# Rezoning Transportation Analysis

Petition Number: 2023-160

Date	Description
12-27-23	First Review (JP)

REZONING PLAN

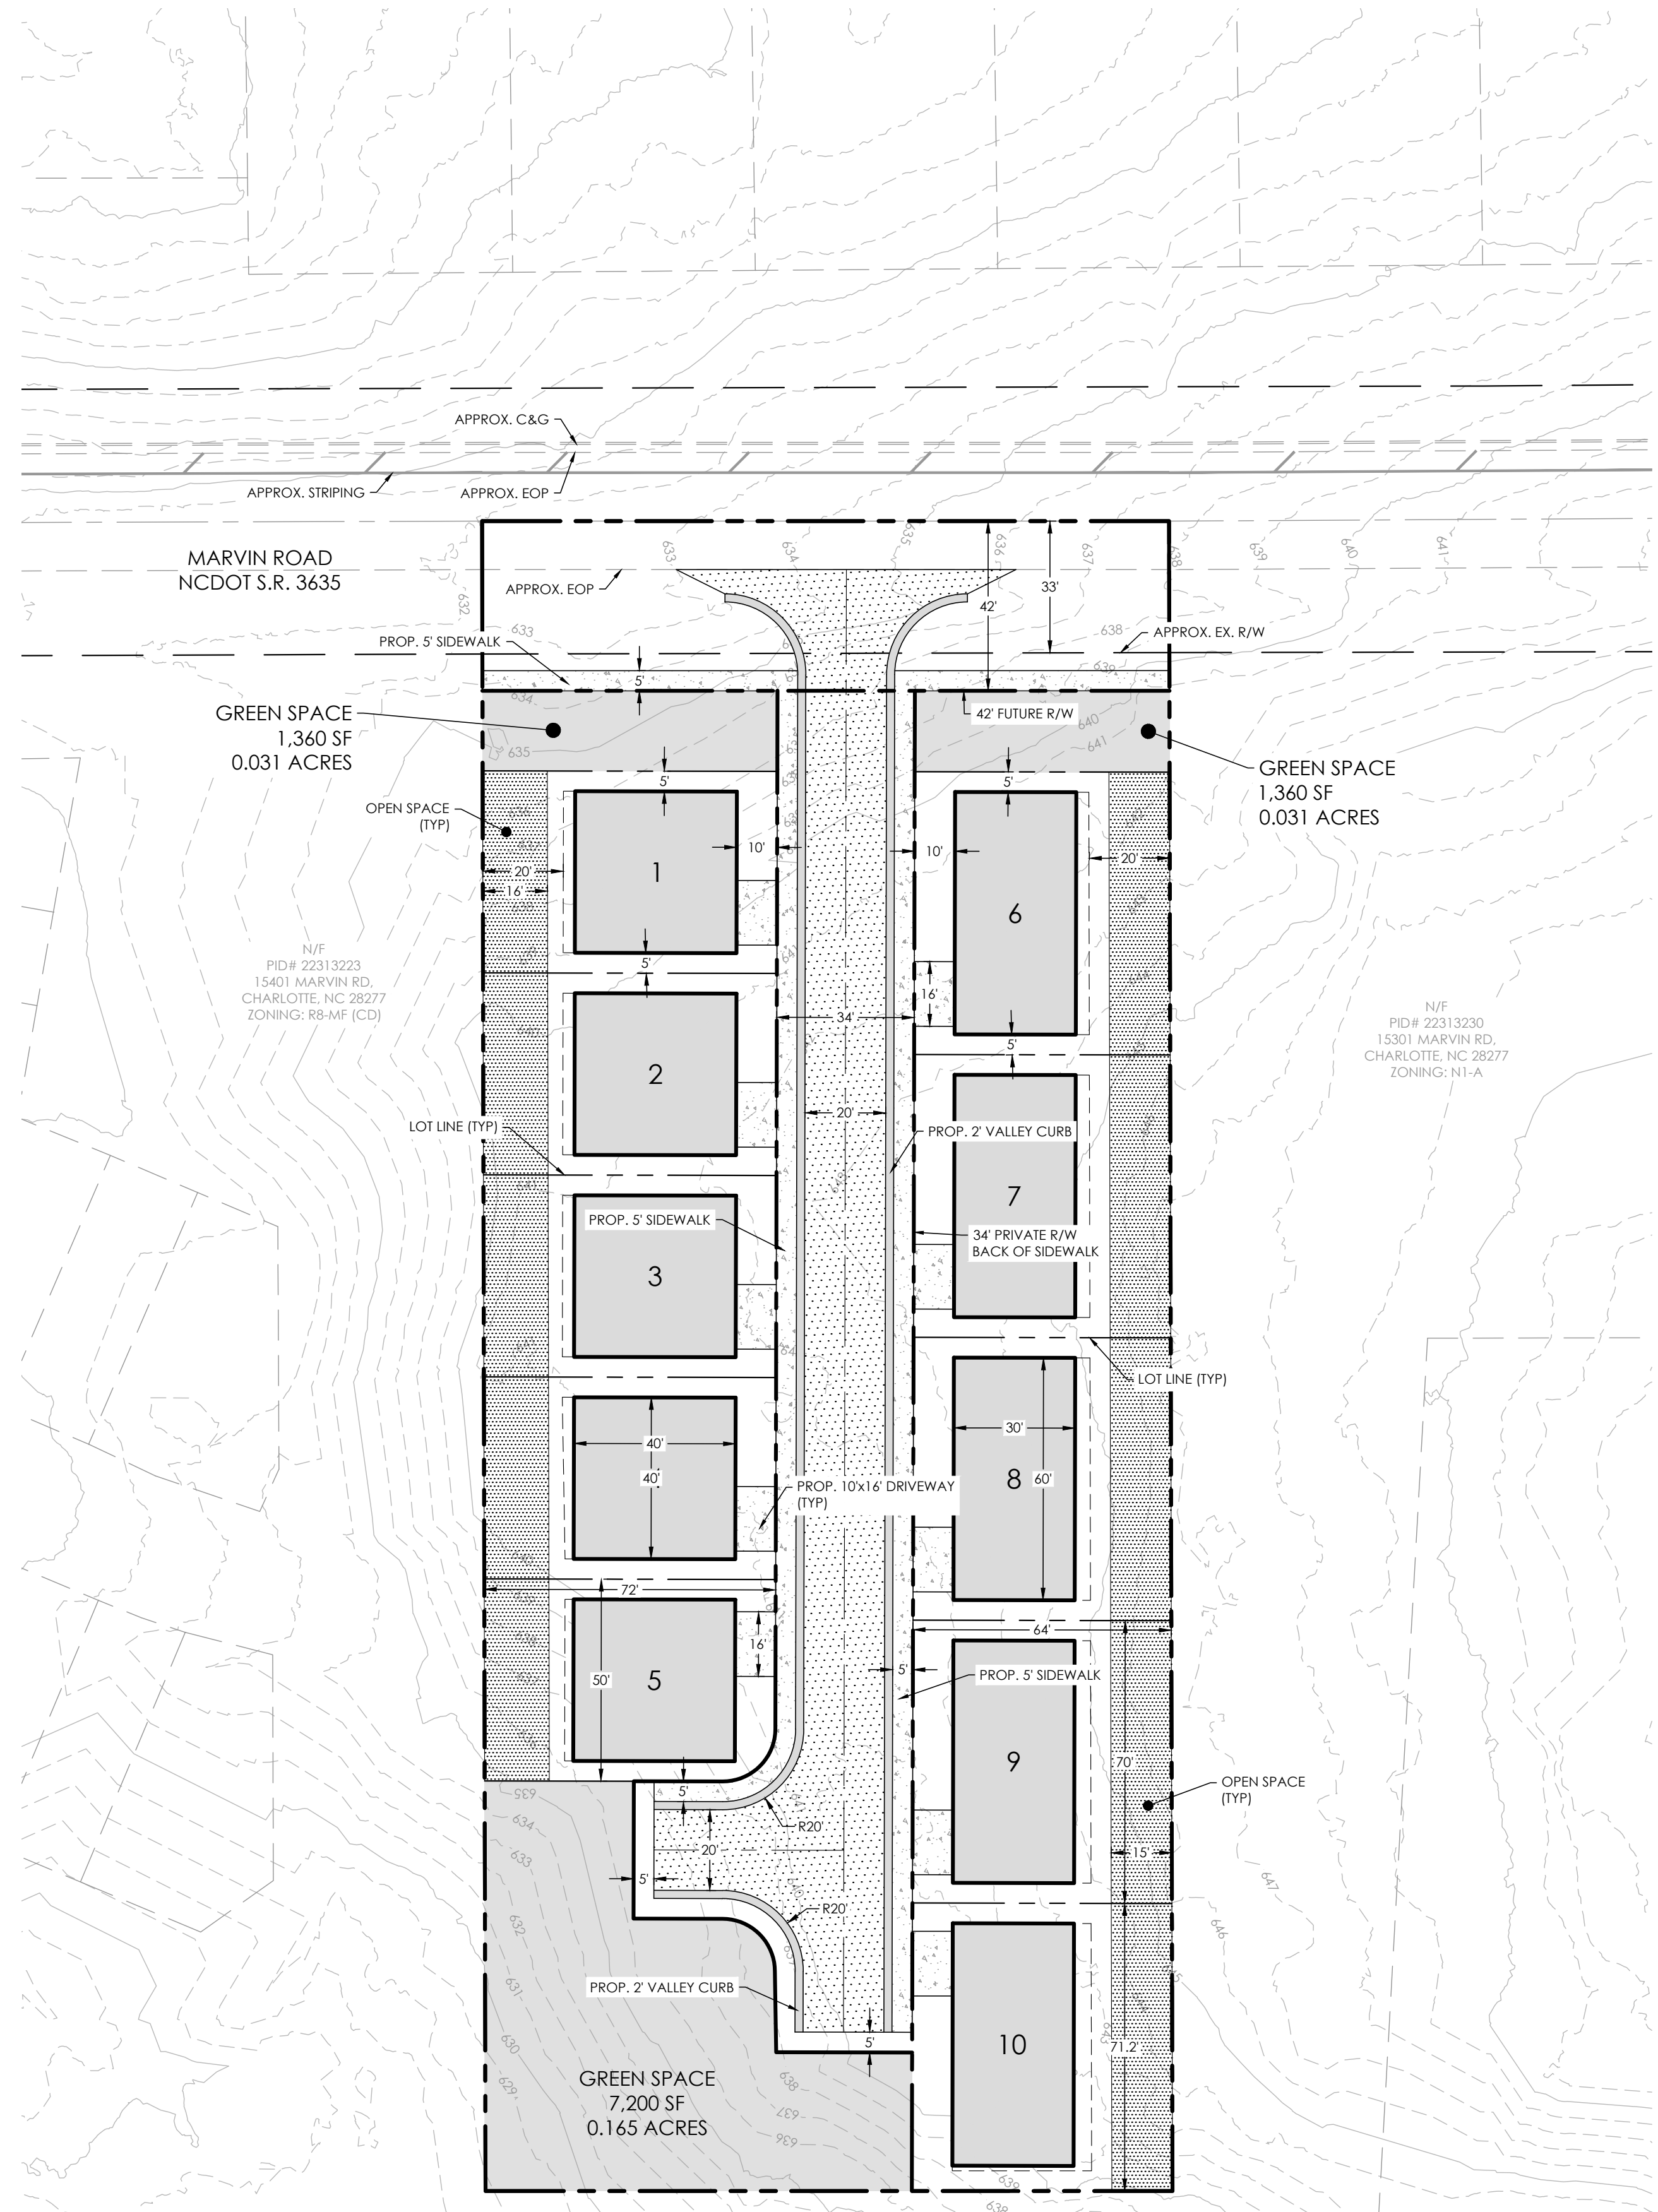
- a. **Marvin Road:** Curb and gutter to be installed 24' from the centerline for a 2+ Avenue with a bike lane as shown on Charlotte Streets Map.

Label and dimension the curb and gutter from the centerline for each road on the site plan.

- 3. Revise site plan and conditional note(s) to commit to dedicate 40' right-of-way from the road centerline. The site plan shall label and dimension the right-of-way from the road centerline.
- 4. Revise site plan and conditional note(s) to commit to installing an 8' planting strip and 8' sidewalk in accordance with the Charlotte Streets Map.
- 5. CDOT requests to revise site plan and conditional notes to commit to 6' sidewalks throughout the development.
- 6. CDOT requests to revise site plan and conditional notes to commit to connecting to Castle Abbey Lane.

7. In coordination with NCDOT, revise site plan to dimension the internal stem from the ROW.
8. Add a conditional note specifying “A Right-of-Way Encroachment Agreement is required for the installation of any non-standard item(s) (irrigation systems, decorative concrete pavement, brick pavers, etc.) within a proposed/existing City-maintained street right-of-way by a private individual, group, business, or homeowner's/business association. An encroachment agreement must be approved by CDOT prior to construction/installation. Contact CDOT for additional information concerning cost, submittal, and liability insurance coverage requirements.”
